Our Ref: WA/94/17/HH

**Town & Country Planning Act 1990 (as amended)
Town & country Planning (Development Management Procedure) (England) Order 2015
Application for Householder Planning Permission**

Development Side extension & garage conversion, new dormers to front and rear elevations, 3 No. roof lights to side elevations, 2 No. solar panels to side elevation & 1 No. new window to front elevation.

Location Byways West Walberton Lane Walberton

BLOCK PLAN (1:500)

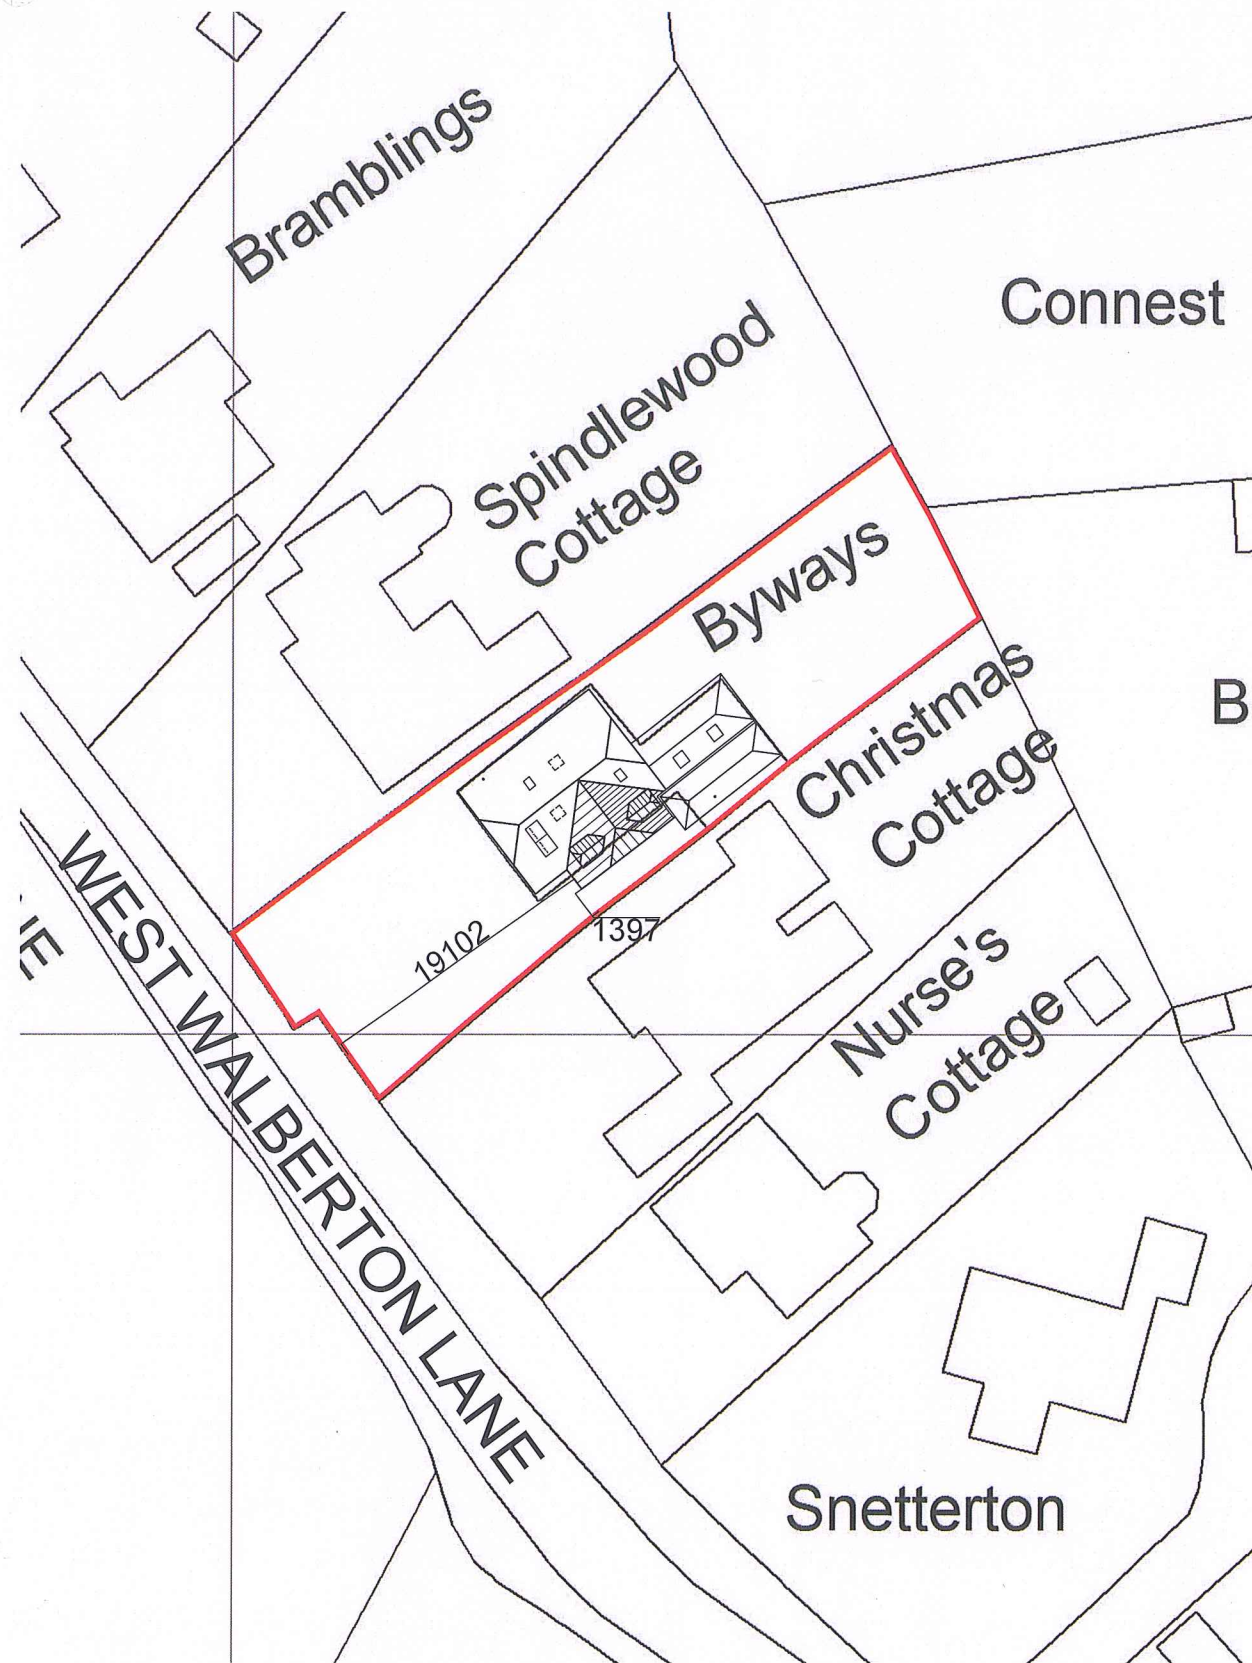
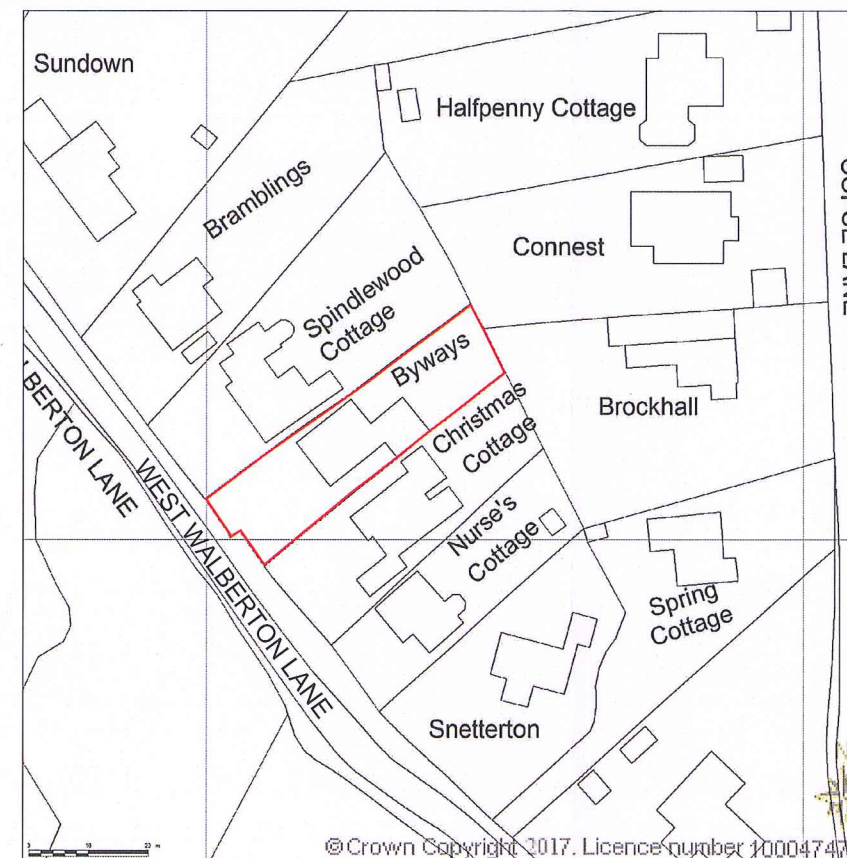
Block Plan

Please submit 1 electronic or 3 paper copies of a block/site plan at a scale of 1:500 or 1:200. Further details of what must be included on the plan can be found in the National Validation Requirements. Please highlight the proposed works.
